**Talavera Road Data Centre Campus Expansion (SSD-24299707)
Additional Matters for Submissions Report**

ATTACHMENT 1

Based upon the Department's review of the information of the EIS, the Department considers further information is required to clarify matters and addresses inconsistencies within the documentation. In this regard the following information is required to be provided:

3 **GFA PLAN - LEVEL 01B**
1 : 500

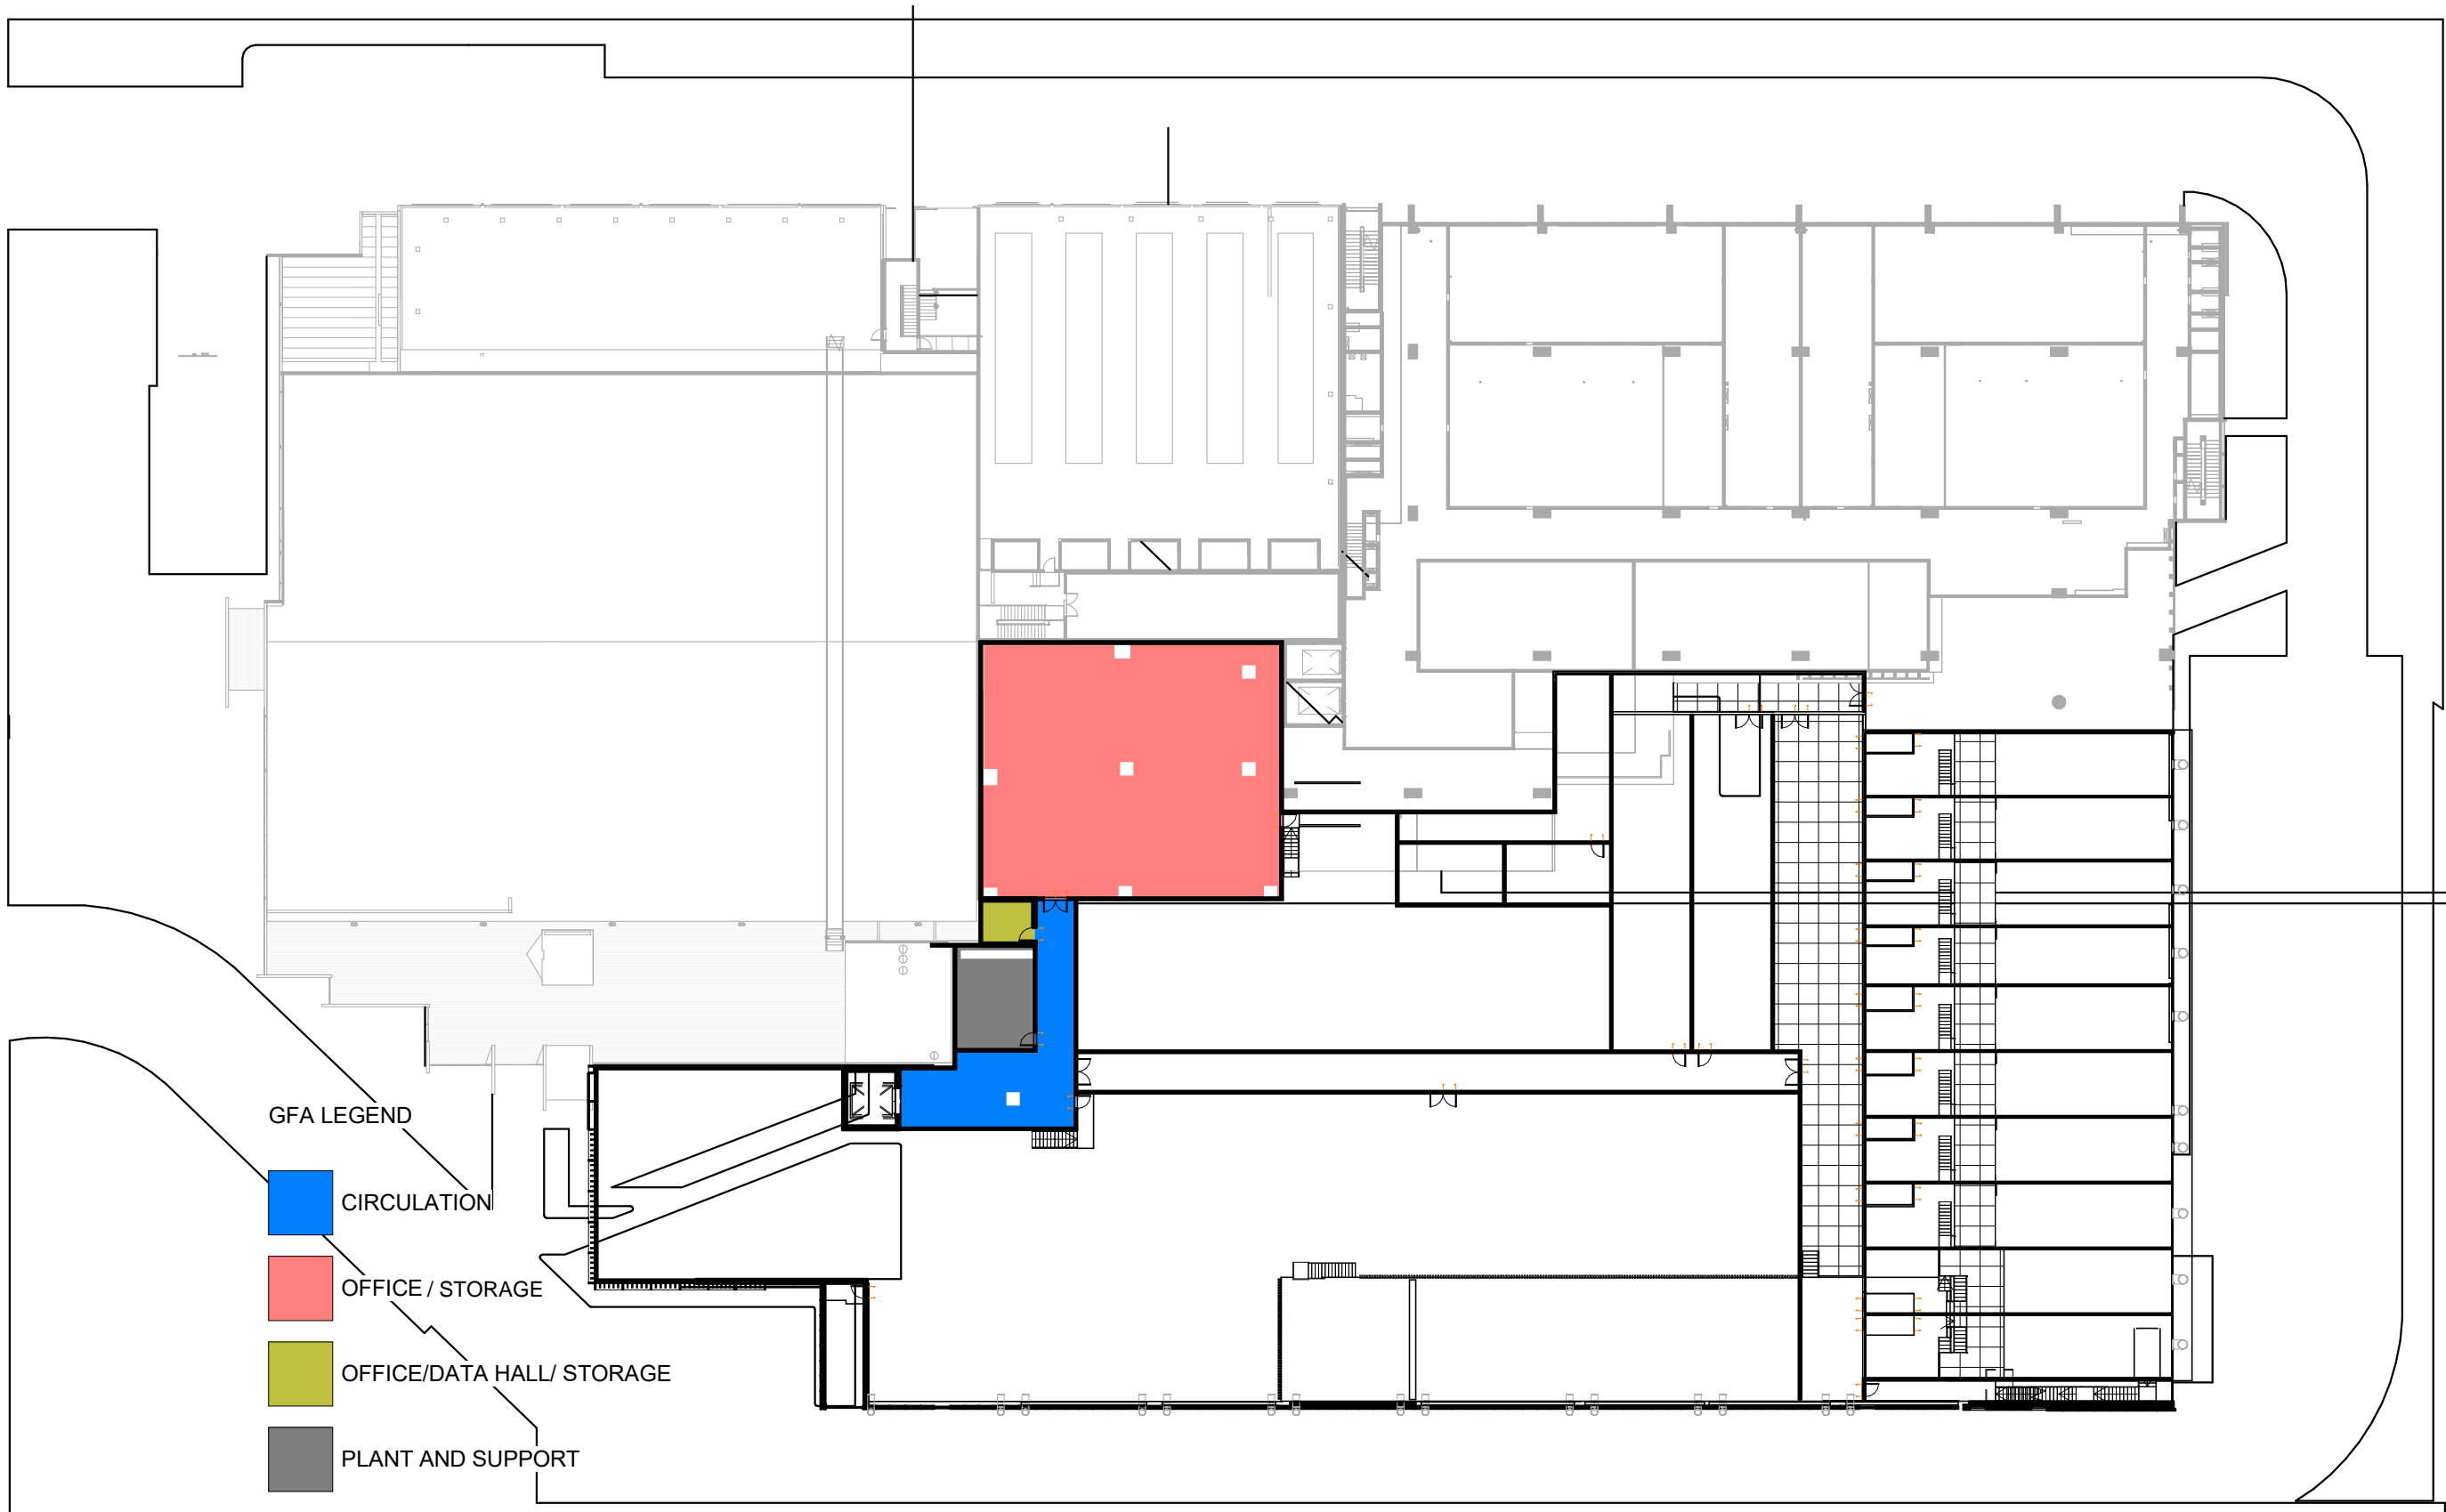
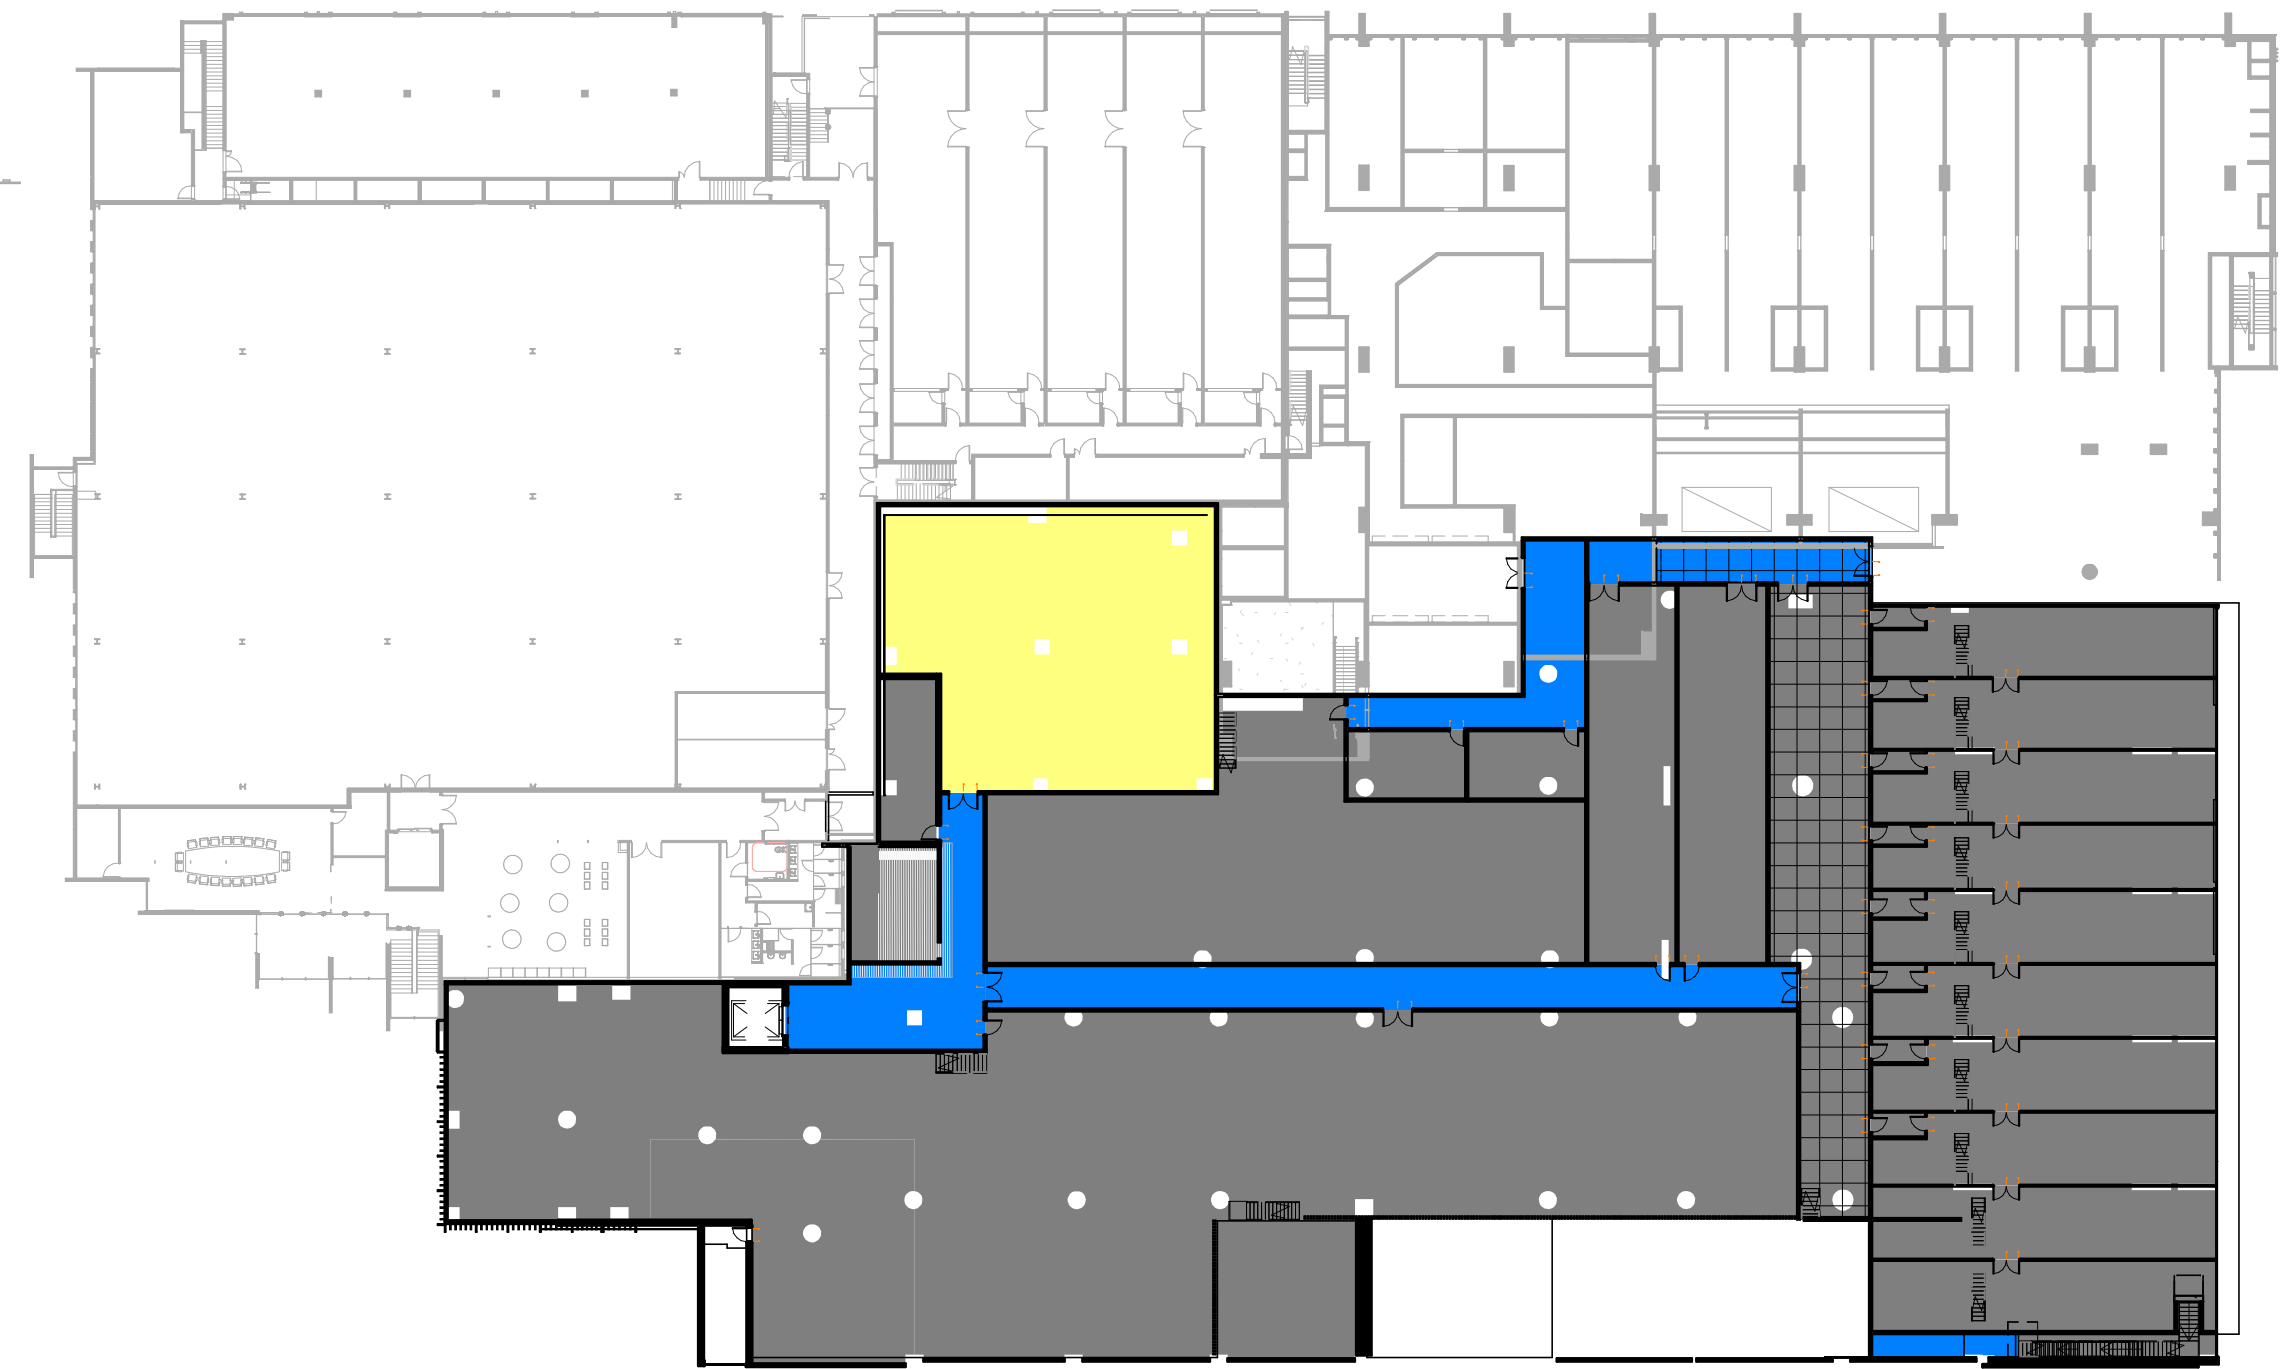
30. The Department notes the GFA figures referred to in the EIS differ slightly from those figures referenced in the architectural plans. Please clarify accordingly.
31. The Department notes the number of proposed construction jobs (1,200 jobs) is significantly higher than comparable projects in the surrounding area. The Submissions Report should clarify the assumptions which have informed this number.
